COMMUNITY SERVICES DEPARTMENT

May 15, 2019

Subject: Lorson Ranch East Filing No. 4 Final Plat (SF-198)

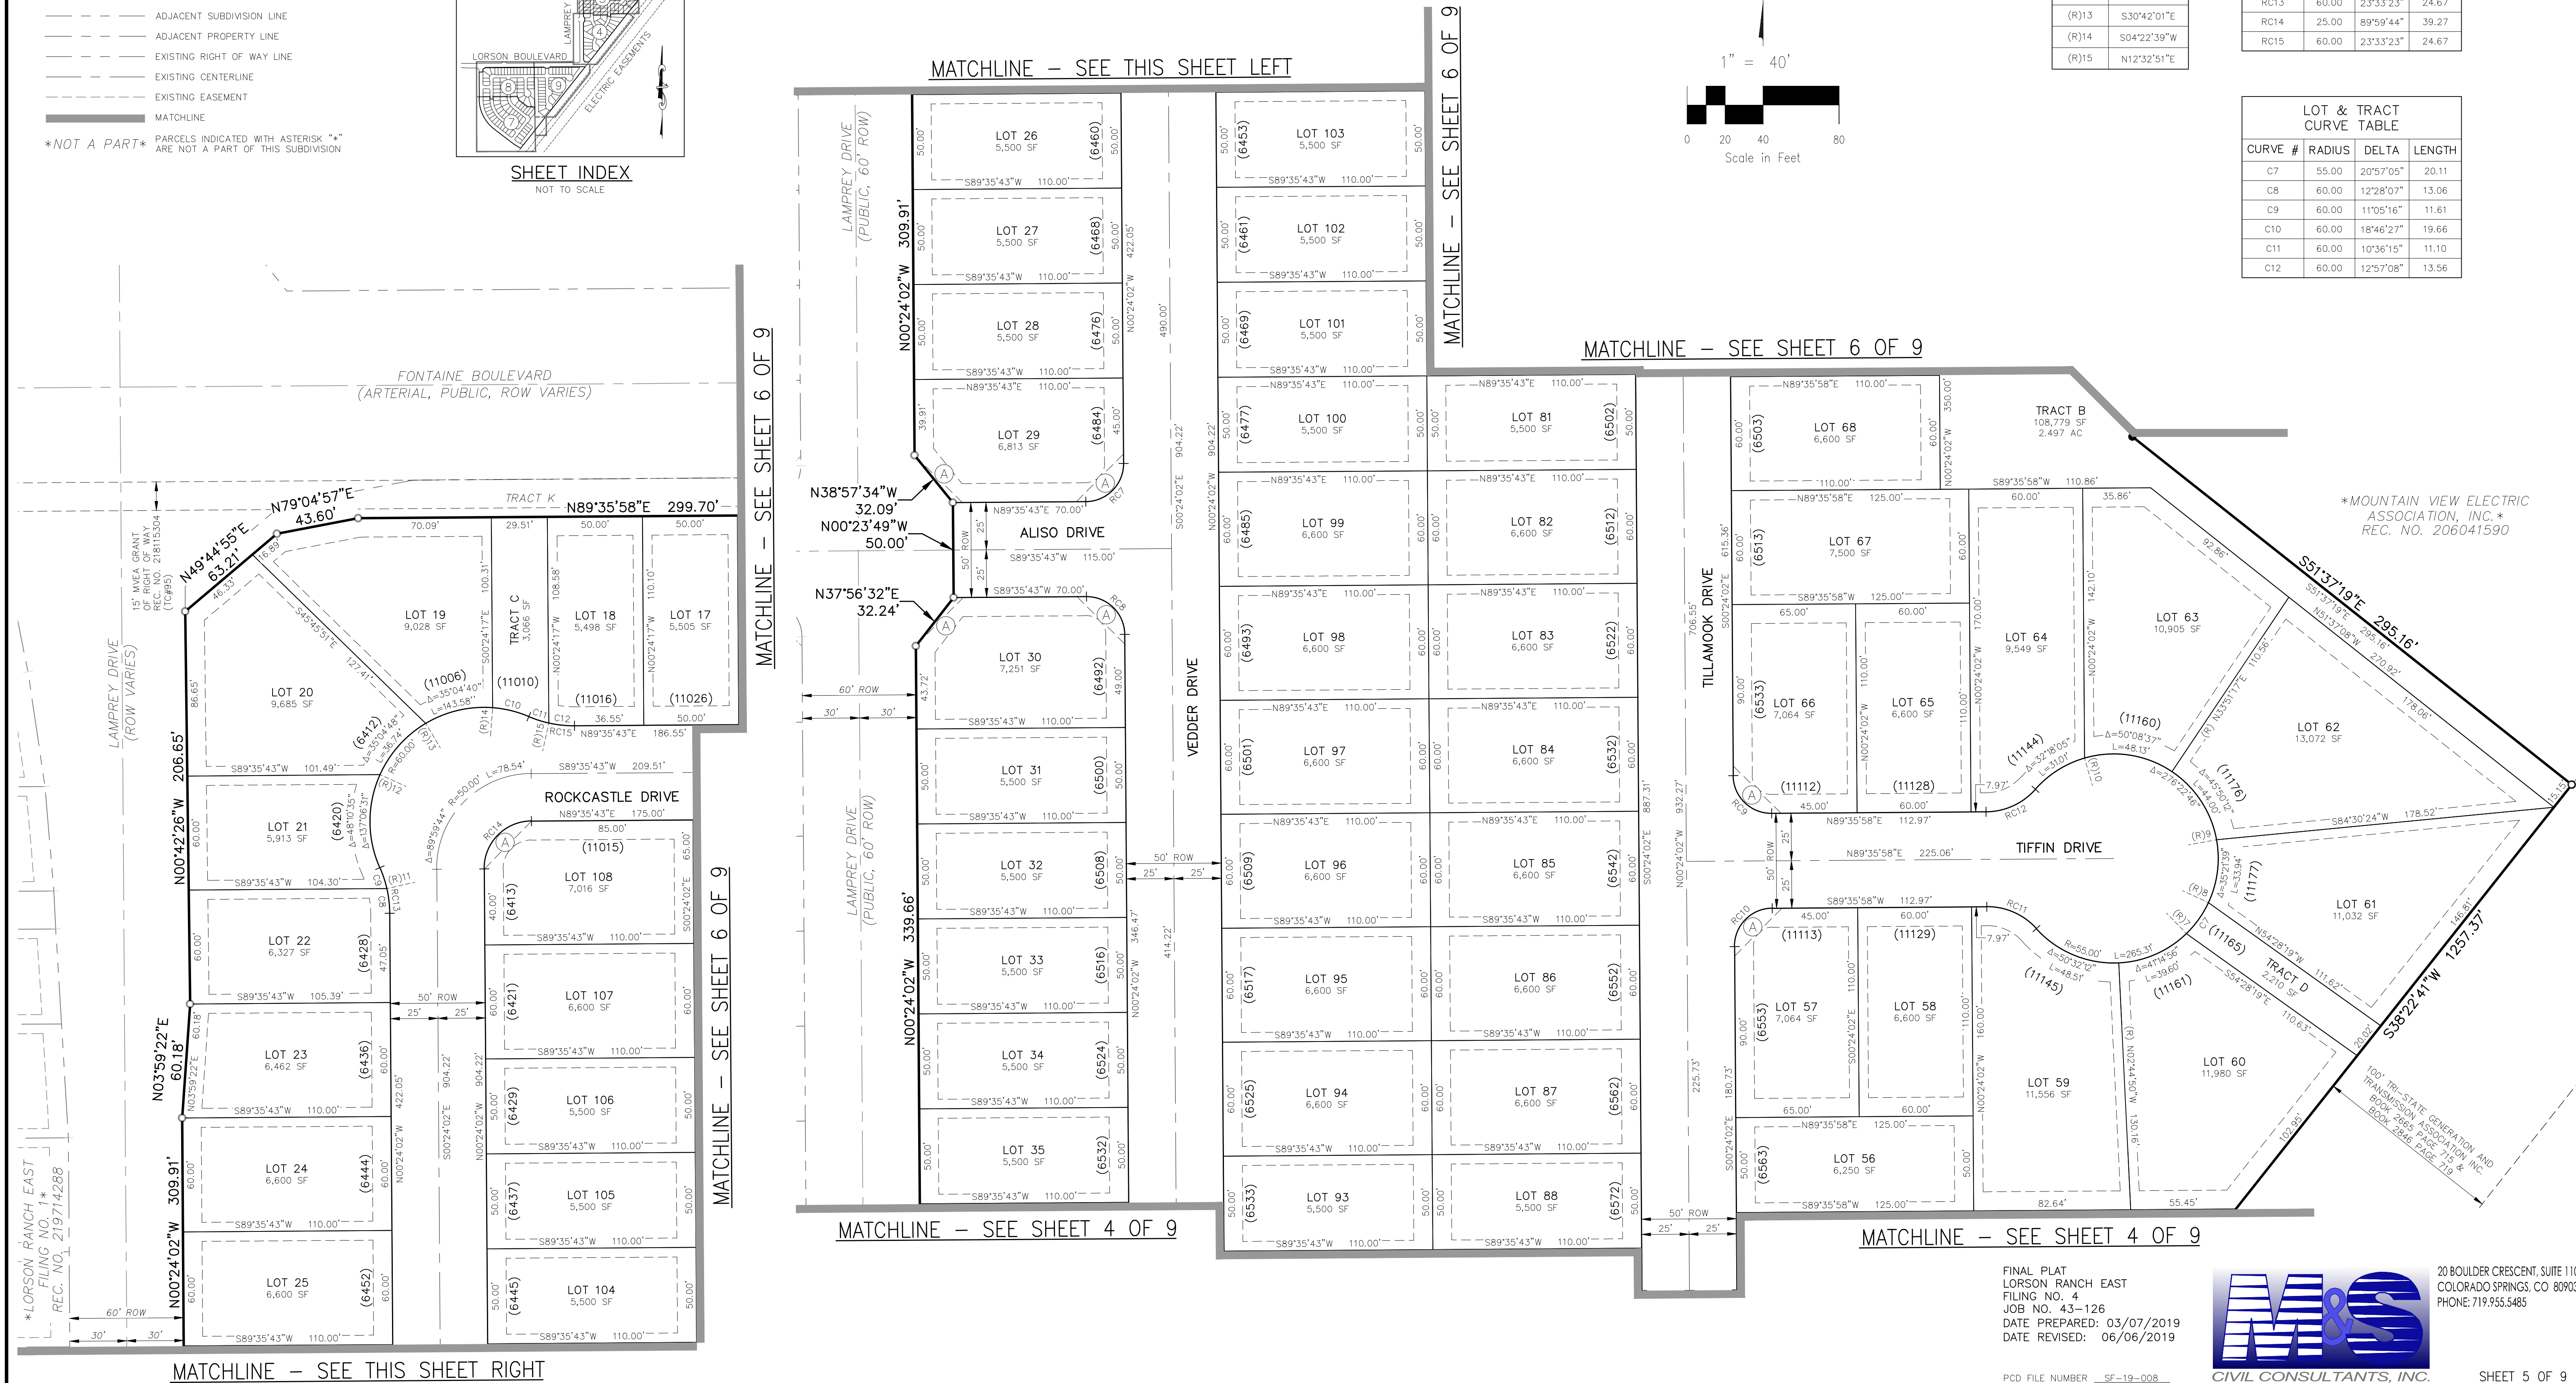
The previously approved PUD and Preliminary Plan drawing included several park sites, including one site within the Filing no. 4 Final Plat site boundary. A park site was previously shown on the PUD and Preliminary drawings within what is labeled as Tract G adjacent to Yocona Drive. Please show the park site on the final plat drawings. This park site would be eligible for an urban park grant from El Paso County Parks.

Recommend to the Planning Commission and Board of County Commissioners that approval of Lorson Ranch East Filing No. 4 Final Plat include the following conditions: (1) Show the park site within Tract G on the final plat drawings consistent with the previously approved PUD Development and Preliminary plan (2) require fees in lieu of land for regional purposes in the amount of \$112,176 and urban fees in the amount of \$70,848. A park lands agreement may be an acceptable alternative to urban park fees provided the agreement is approved by the County and executed prior to recording the final plat.
